Subject: Re: SP-26-00010 Brown Road Estates II - Notice of Application

Fire Marshal comments
Brown Road Estates II
SP-26-00010

TO: All Staff
FROM: Public Works Plan Review Team
DATE: September 29, 2026
SUBJECT: SP-26-00010 Brown Road Estates II

CRUSE & ASSOCIATES  
PROFESSIONAL LAND SURVEYORS  
217 E. Fourth St. P.O. Box 959  
Ellensburg, WA 98926 (509) 962-8242  
BROWN ROAD SHORT PLAT NO. 3

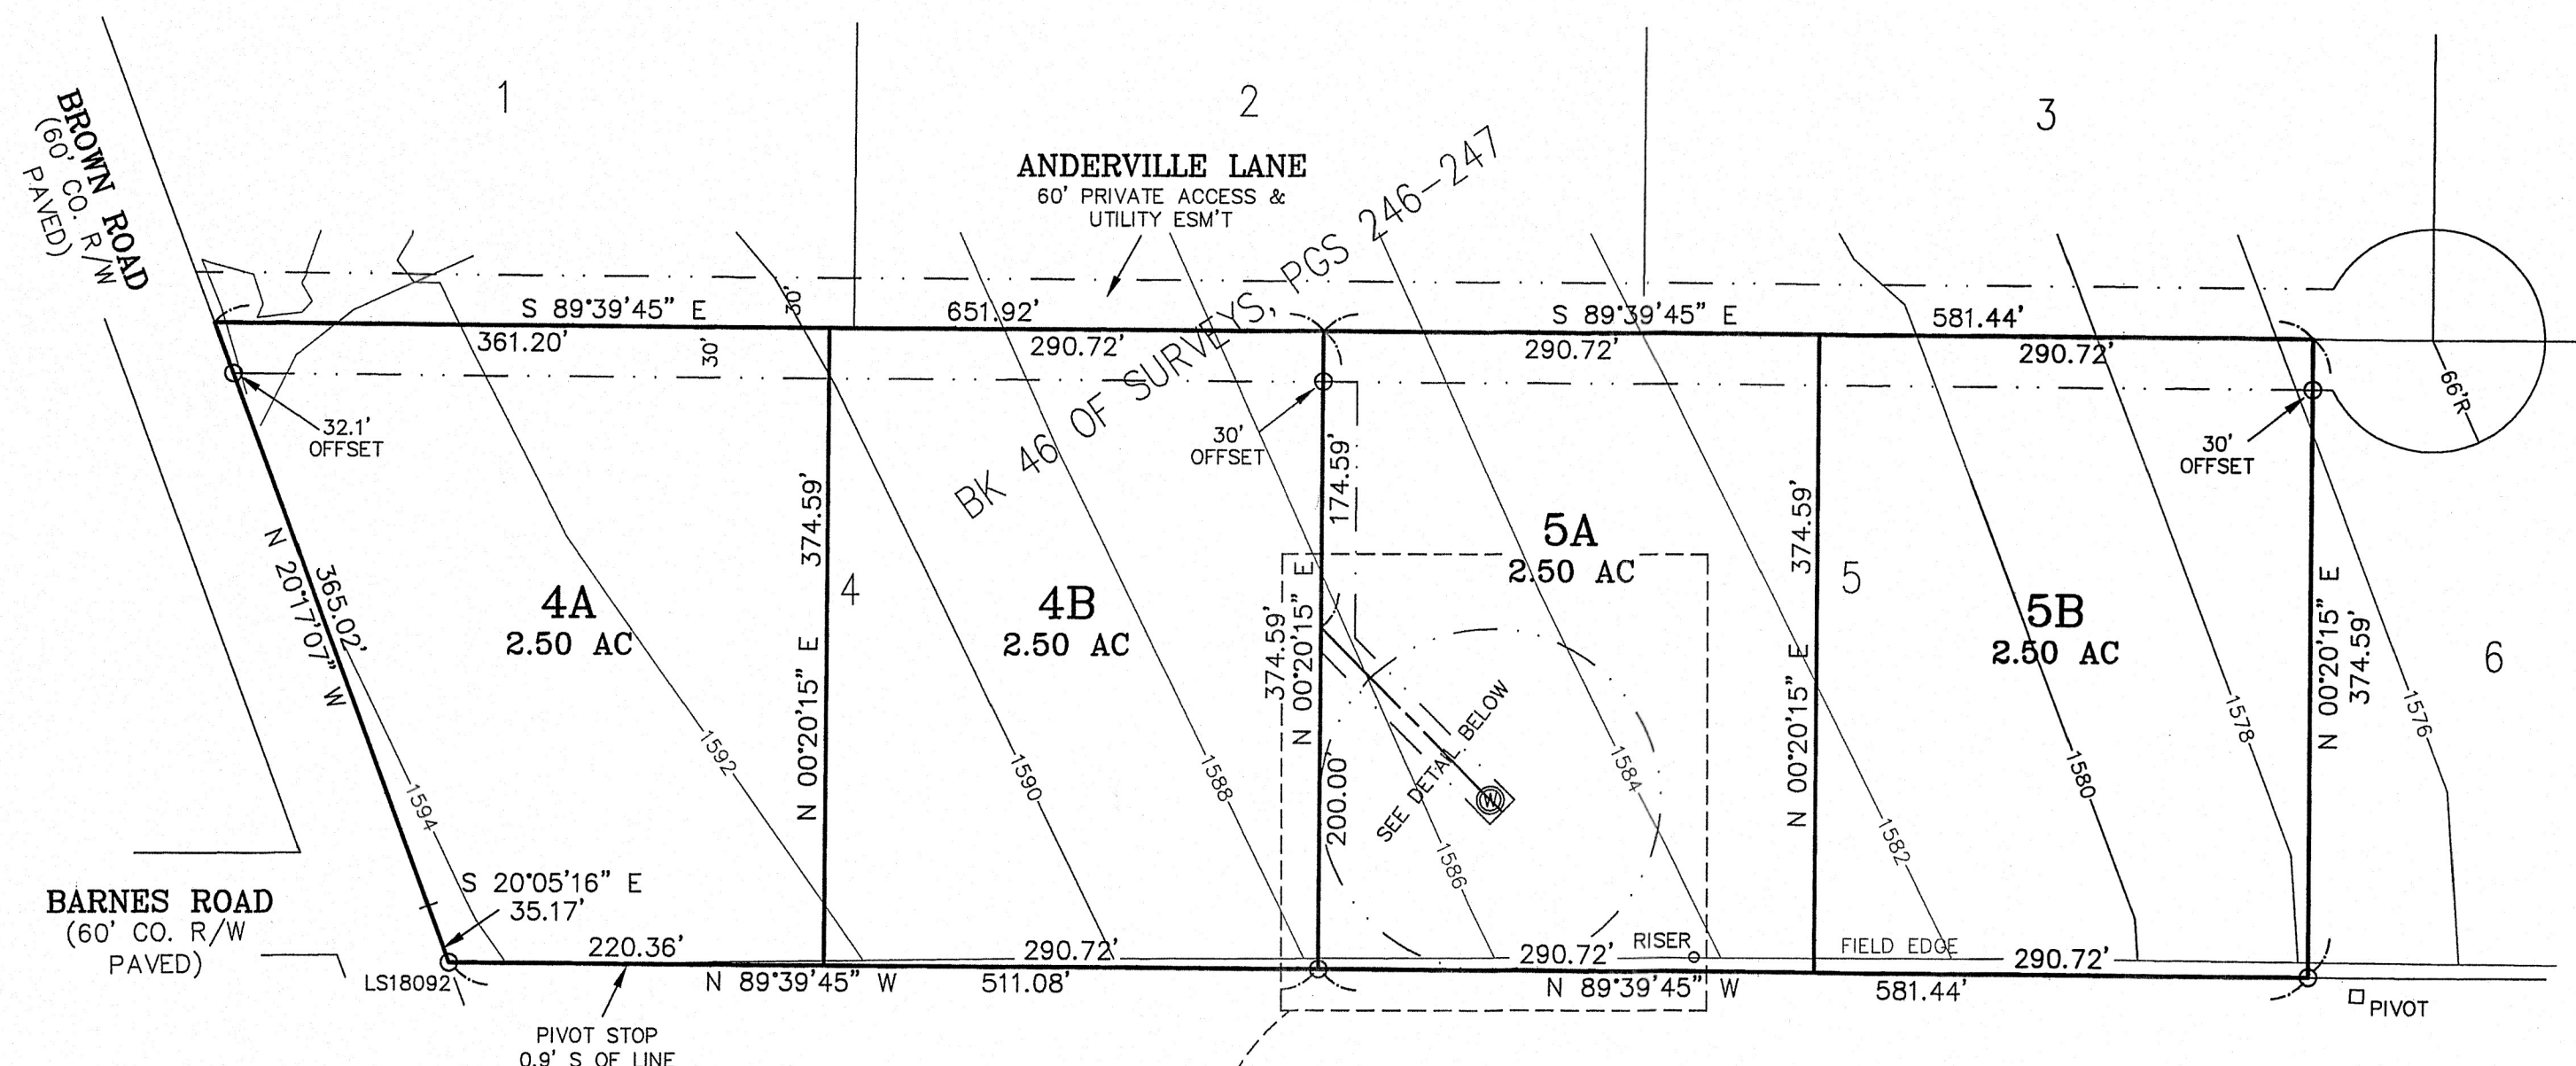
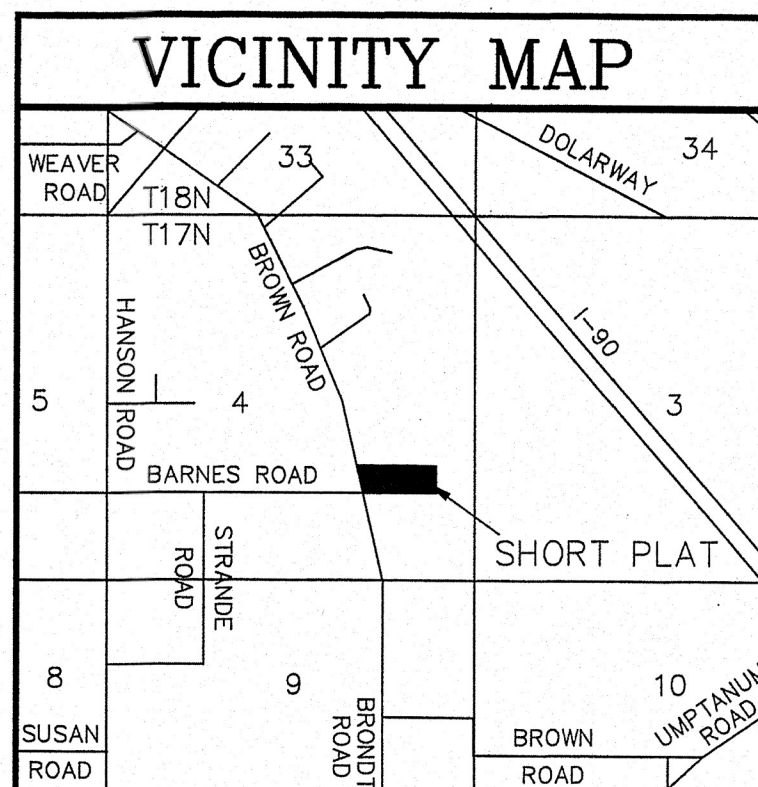
Fire apparatus access is required for this application. The roadways and maneuvering areas as indicated in the application do not adequately provide required fire apparatus access. Provide fire apparatus access roads with an unobstructed width of not less than 20 feet, an unobstructed vertical clearance of not less than 13.5 feet, with an all-weather driving surface and capable of supporting the imposed loads of fire apparatus. Access roads shall extend to within 150 feet of all portions of the facility and all portions of the exterior walls of the first story of the building.

Approved fire apparatus turnarounds are required for this project. The indicated provisions for turning around fire apparatus are not adequate. Provide an approved turnaround constructed in accordance with the International Fire Code Appendix D.

SURVEY	1. Please provide reference to Anderville Lane Easement document, to show legal access to proposed parcels. The following comments are only in regards to final submittal. 2. Please show or note Basis of Bearing. 3. Please describe "Found pin and cap", or change legend to include cap details. 4. Property corners need to be set in the field and shown on the face of the Short Plat. (JT)
TRANSPORTATION CONCURRENCY	Please be aware that additional short plats in this area may trigger further transportation concurrency requirements based on increasing lot numbers. Currently the estimated additional trips per day provided by the two extra lots are equal to 18 trips per day. Once more than 41 trips per day are generated a TIA will be required. It is advised that if additional divisions of lots are to be
